## EL PASO COUNTY GRADING AND EROSION CONTROL PLAN CHECKLIST

EPC Project Number: PPR2341 & SF2325

SHEET 9 OF 19
JOB NO. 25188.14

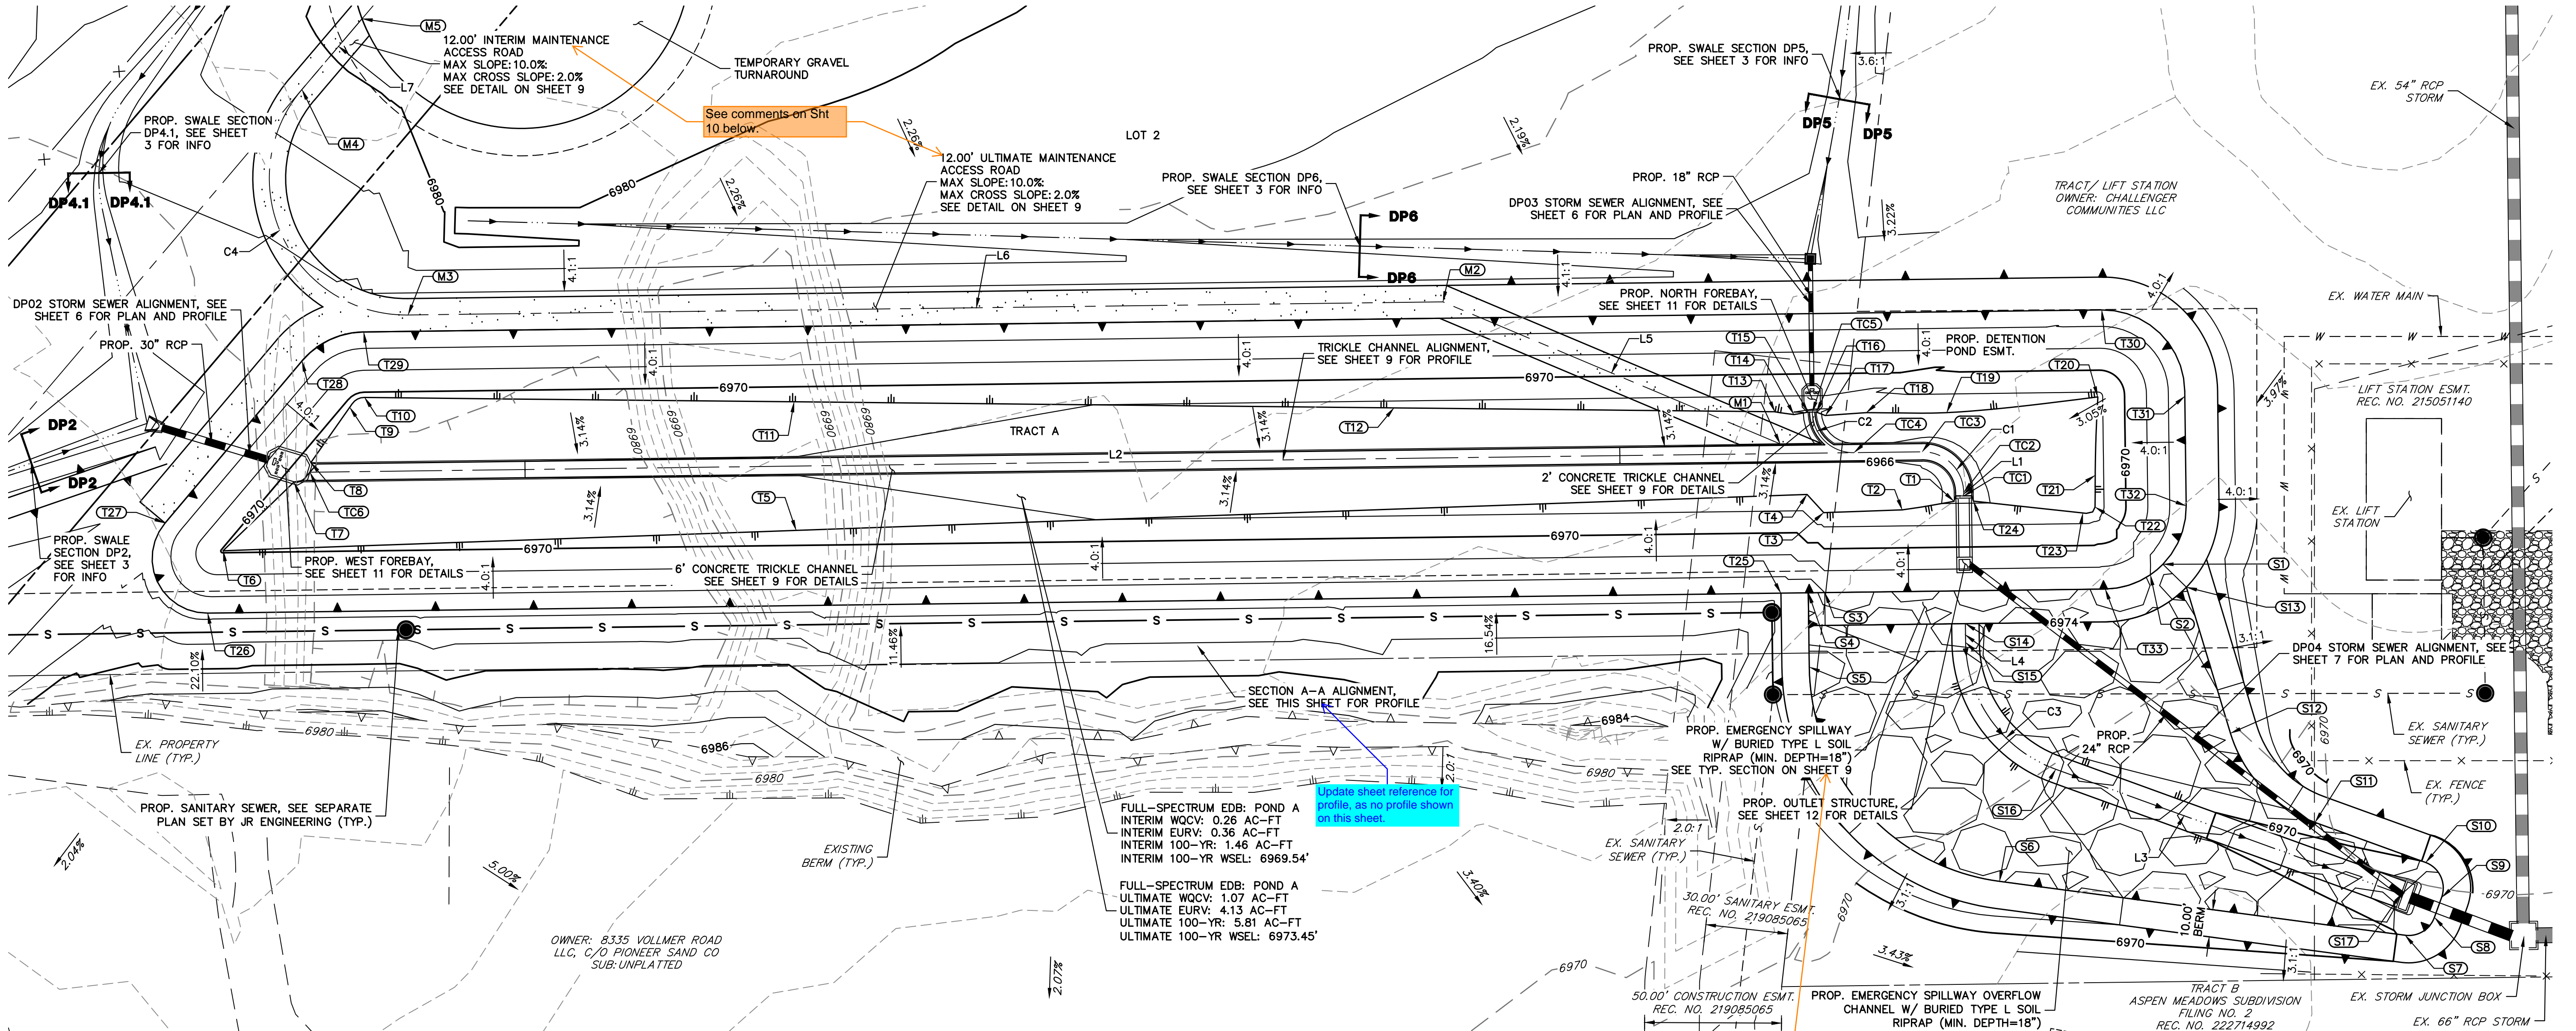
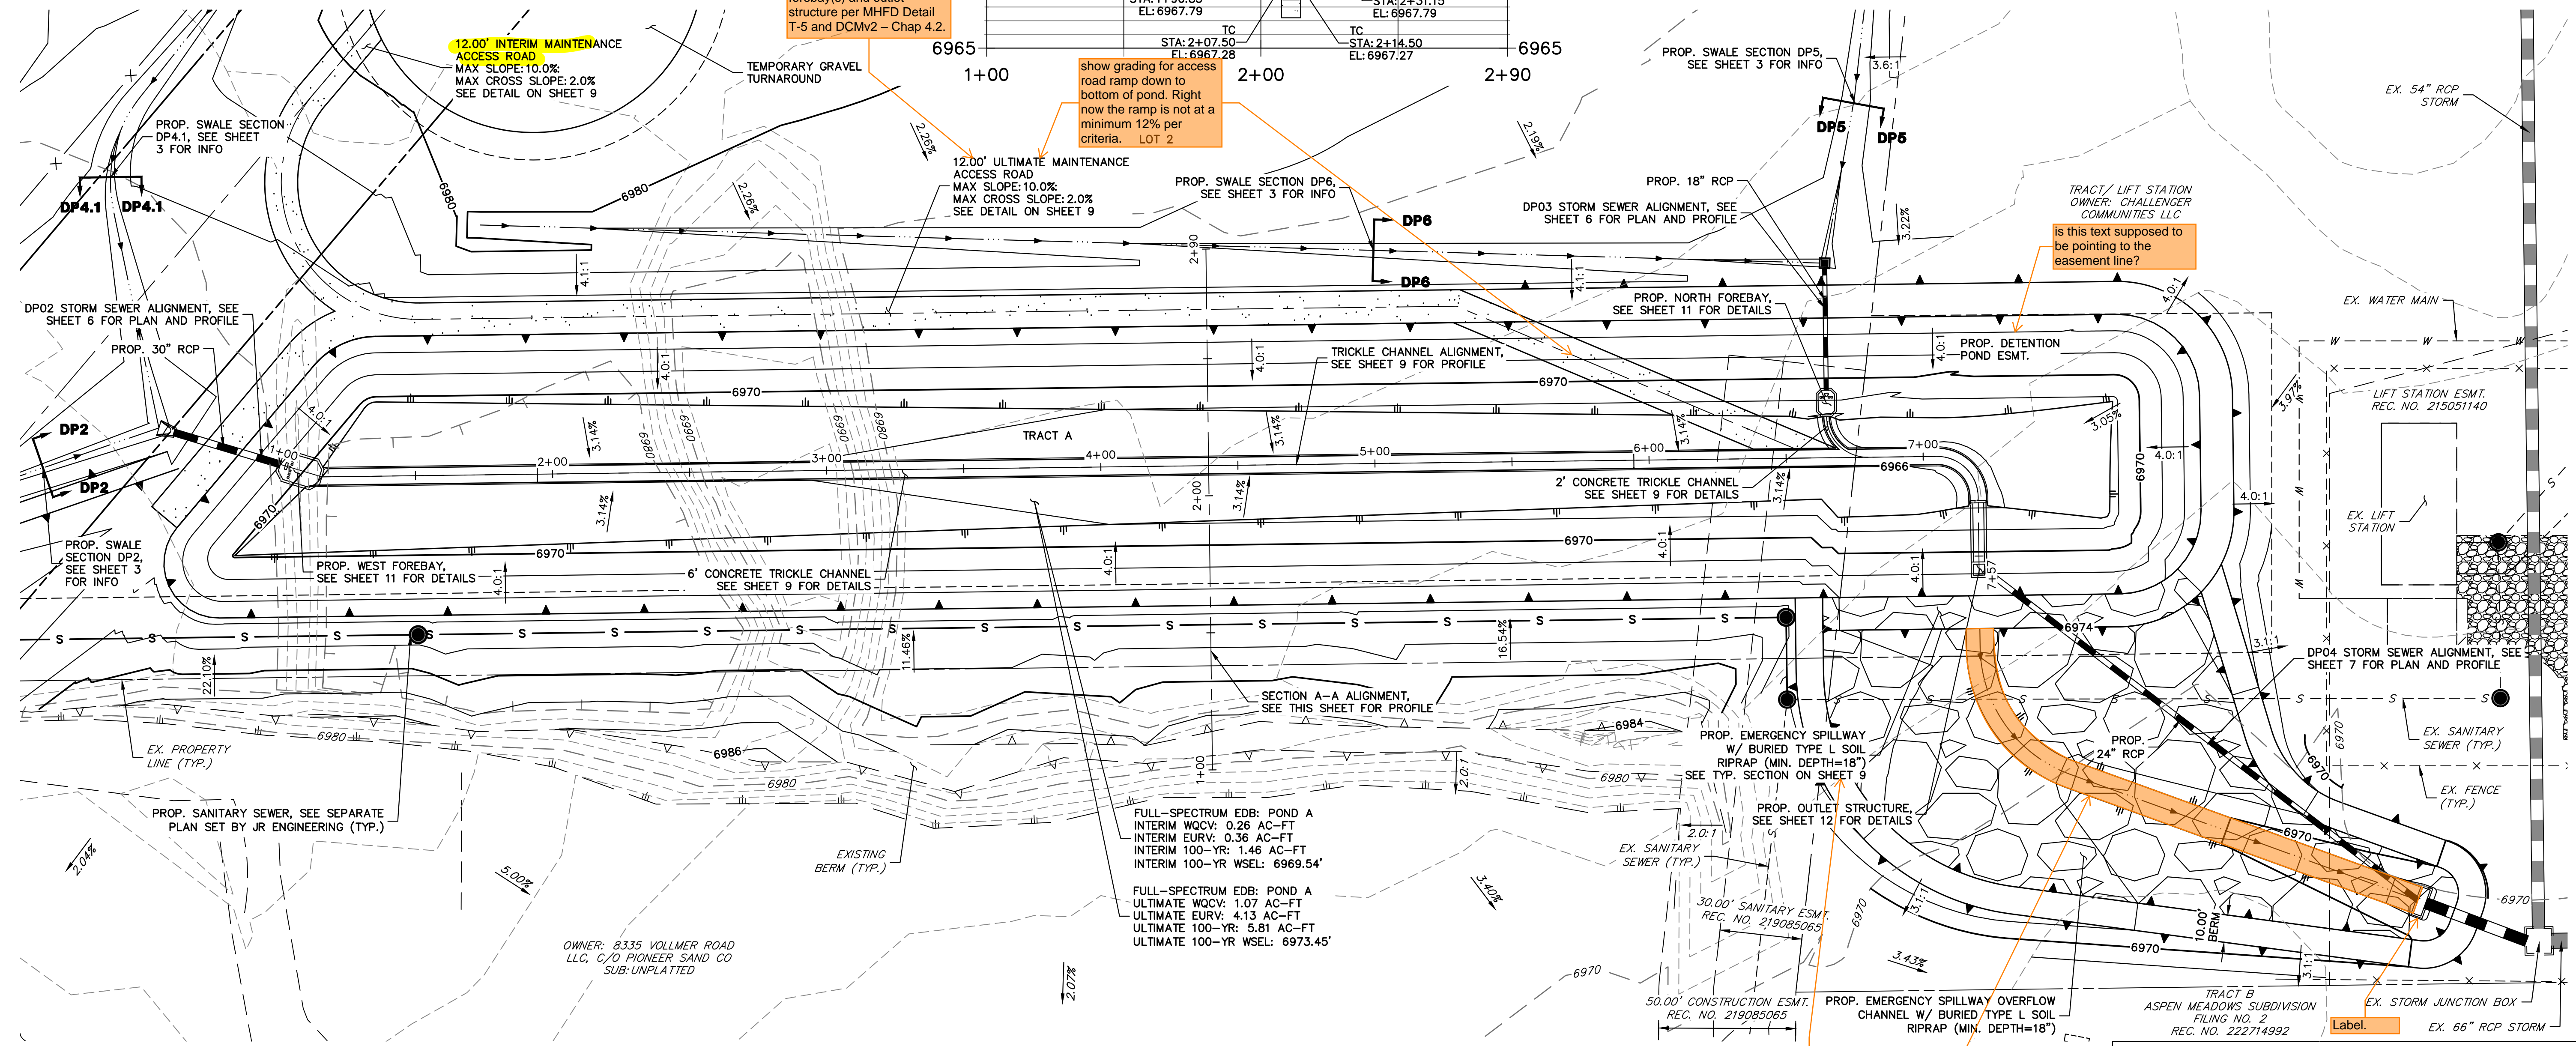
See my comments in:  
 - FDR pdf page 14-15  
 - GEC Plan sheet 9

SHEET 4 OF 19  
 JOB NO. 25188.14

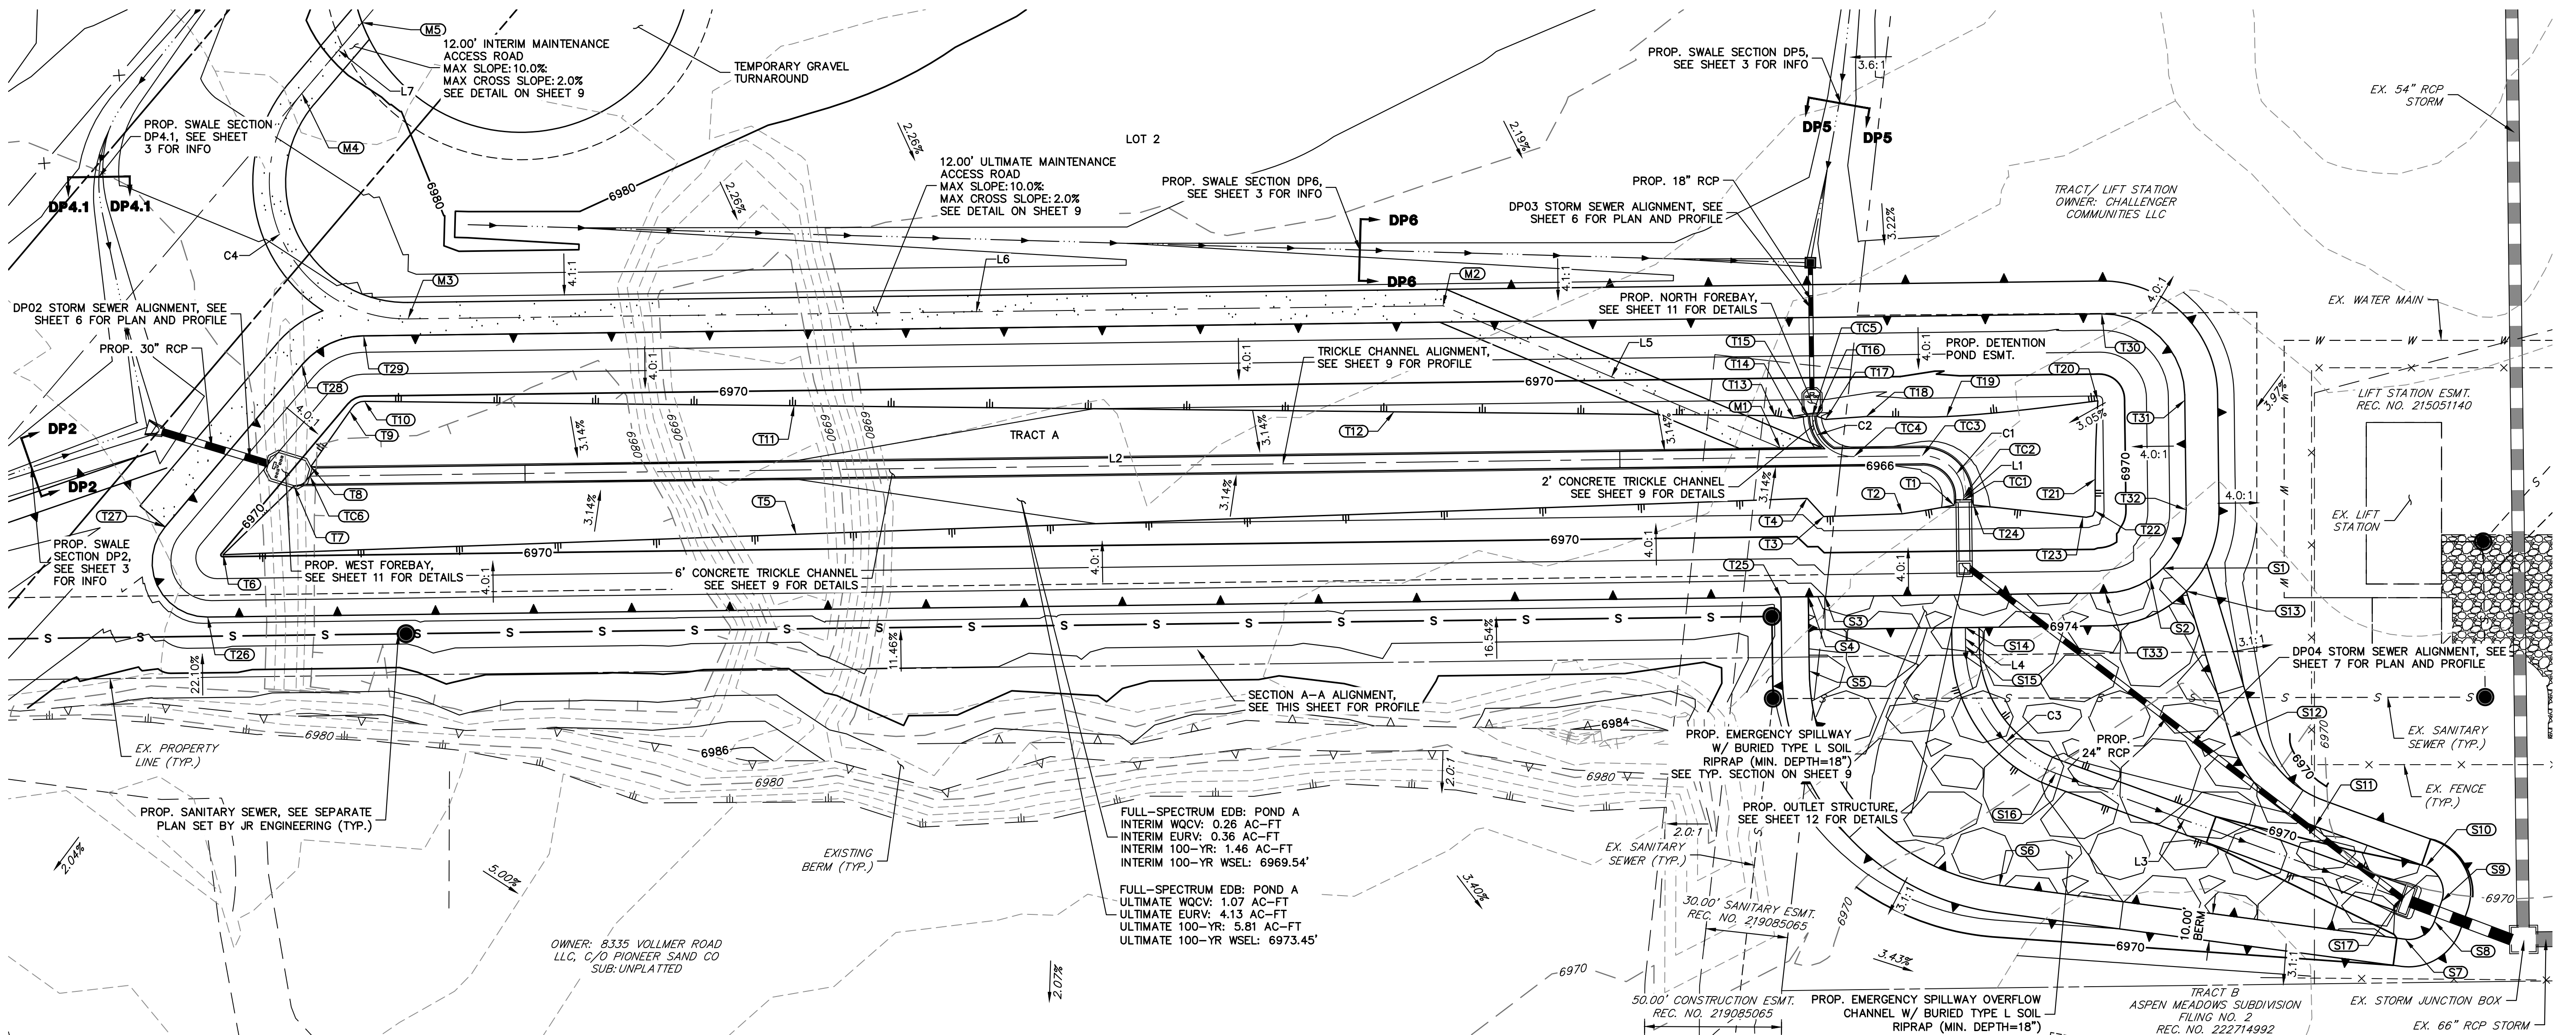
See my comment on Sheet 5 of GEC Plan regarding TSB's and TSW's.
